Our Case Number: ABP-319866-24

Re: Proposed development known as North Irish Sea Array ("NISA") Offshore Wind Farm
Located off the coast of Counties Dublin, Meath and Louth (www.northirishsearraysid.ie)

Observations on Application 319866, North Irish Sea Array (NISA) wind farm

Image 24.1 Onshore cable route sections

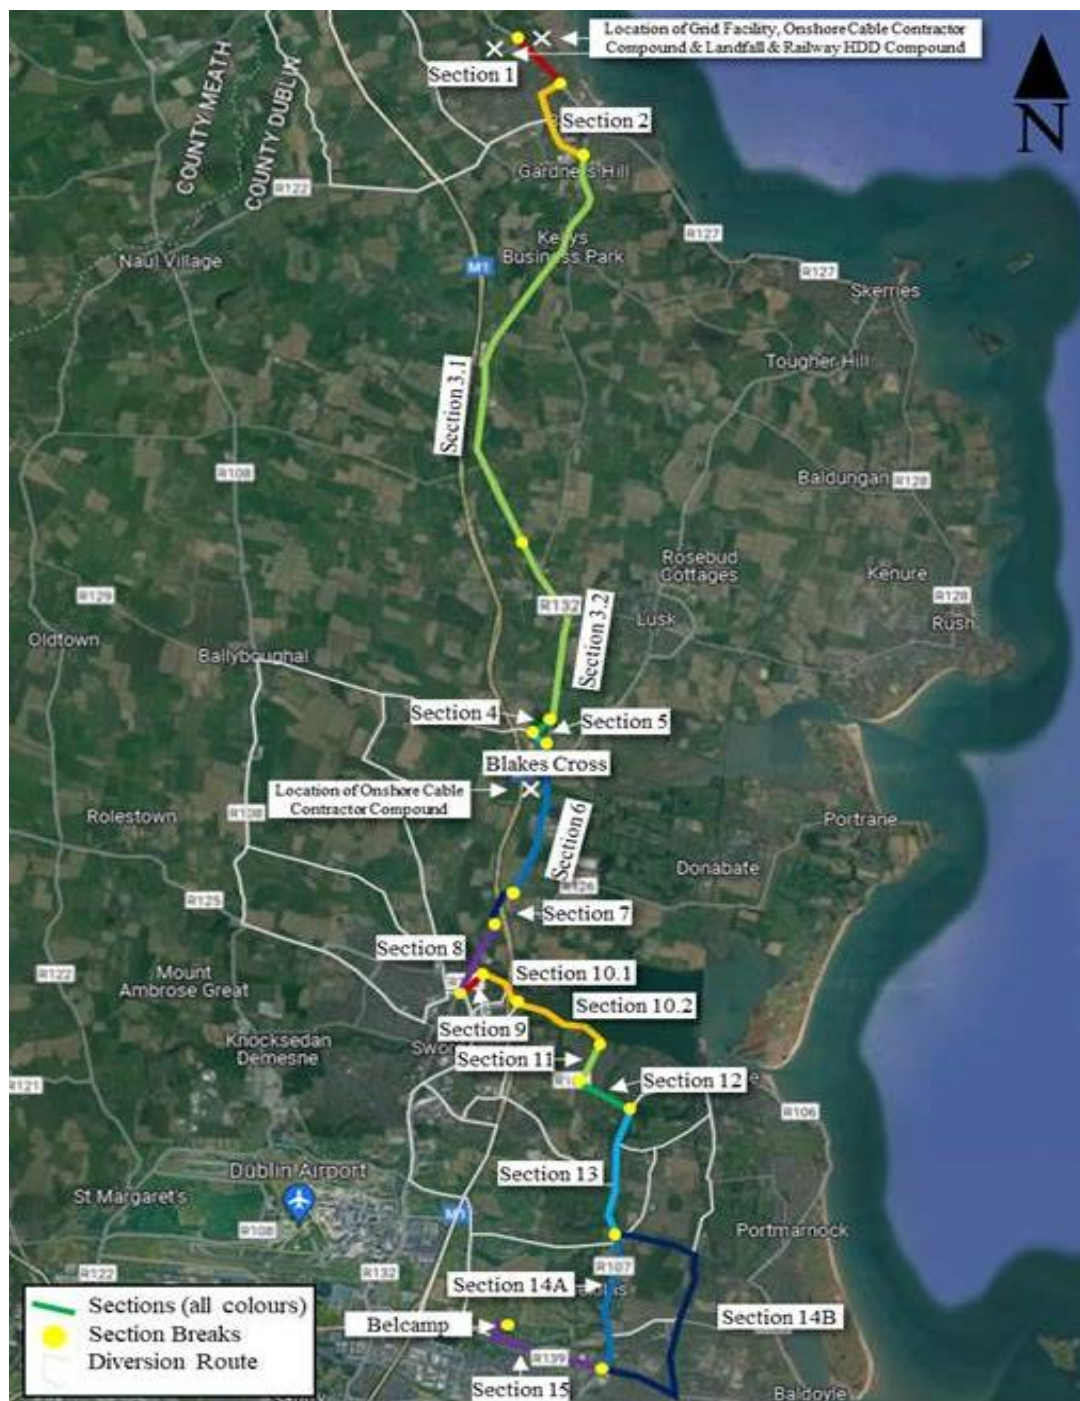
In particular, the Board has referred to the *NISA Environmental Assessment Report, Volume 4, Onshore Chapters, Chapter 24, Traffic and Transportation*. We have noted that **Section 3.2 of the onshore cable** is due to be routed along the **R132 roadway** outside Corduff NS. Tables 24.42, 24.43 and 24.44 advise of a 2-week full road closure of a “negative, significant” nature as well as other temporary 200m partial road closures over 99 weeks of construction. We have also noted that parking for 104 staff is planned at the proposed Blakes Cross Cable Compound (Table 24.35) and will introduce increased daily traffic close to the school, in addition to the daily construction vehicles.

Observation 1: The Board of Management requests that An Bord Pleanála recognises that the layout of the R132 road layout has been re-designed by Fingal County Council during 2023/2024 to install both a northbound and a southbound shared cycle lane from Ballough to Blake’s Cross. These works are still underway and are nearing completion. The Board is surprised to see plans to dig up this multi-million-euro road project so soon after its installation. We are aware that some Fingal County Councillors have already expressed a preference at recent council meetings for routing the cabling adjacent to the M1, which would be far less disruptive. Regardless, our main concern is that the current R132 road design has introduced a significantly narrowed roadway, has halved the school parking and drop-off zone and has re-located the parking from the now defunct hard shoulder to a new parking zone situated between the narrowed roadway and the new shared southbound cycle lane. The road conditions are now treacherous outside the school for our school community. The majority of our students/families and staff will continue to be reliant on the Department of Education school bus service or car transport for the foreseeable future, based on our school’s location, our widely dispersed rural/urban catchment area and the absence of safe pedestrian or cycle routes to join local roads to the R132. The NISA Traffic Data Collection Surveys of 31/03/2022 and 20/09/2022 (Section 24.2.2) were conducted prior to this significant change

in the R132 road layout and function. The information in Table 24.17 on the “Characteristics of the Road Infrastructure Route Sections ...” is no longer accurate for the R132 at Corduff NS. It is requested that additional traffic surveys are conducted to gather more accurate and current data before plans for the cabling route and construction schedule are finalised.
